17 April 2018

PACIFIC HIGHWAY (A43): SSD 8533, VALES POINT SOLAR PROJECT, LOT 150 DP 755266, LOT 102 DP1170921, LOT 7077 DP1056107, LOT 1 DP1195160, LOT 7497 DP 1165634, LOT 4 DP 915257, LOT 1 DP 1166358, LOTS 22 AND 29A DP755242, VALES ROAD, MANNERING PARK

Roads and Maritime response

Figure 5.2 : Proposed Access Upgrade at Pacific Highway / Site Access

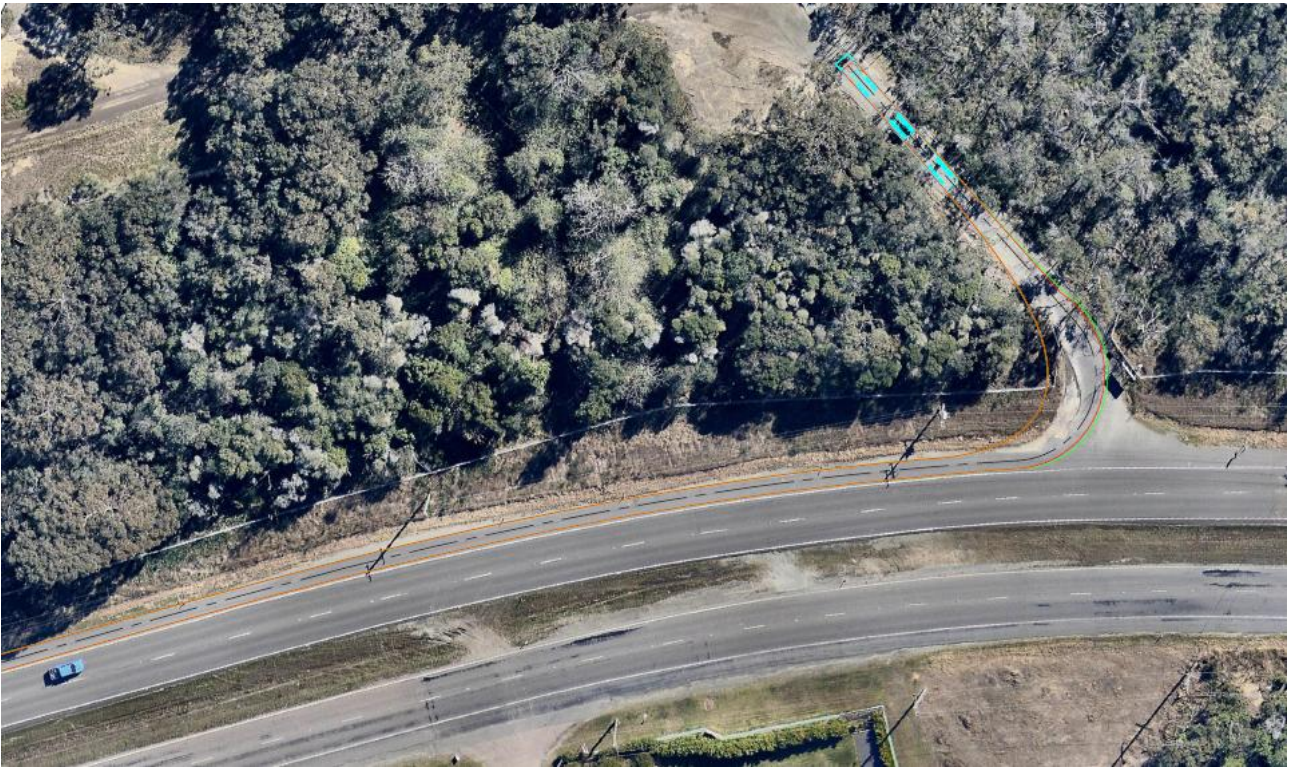
Roads and Maritime has reviewed the information provided and raise no objection to the proposed solar project development in principle. However Roads and Maritime has concerns regarding the proposed use

of the existing access from the Pacific Highway. The proposed access treatment does not comply with minimum design safety standards and has the potential to compromise the safety and efficiency of the classified (State) road, and is contrary to Objective (1)(a) of *Section 101 within the State Environmental Planning Policy (Infrastructure) 2007*.

Roads and Maritime recommends that DPE consider requiring the rationalisation of access to the site by requiring all access be via the proposed upgraded intersection at Ruttleys Road.
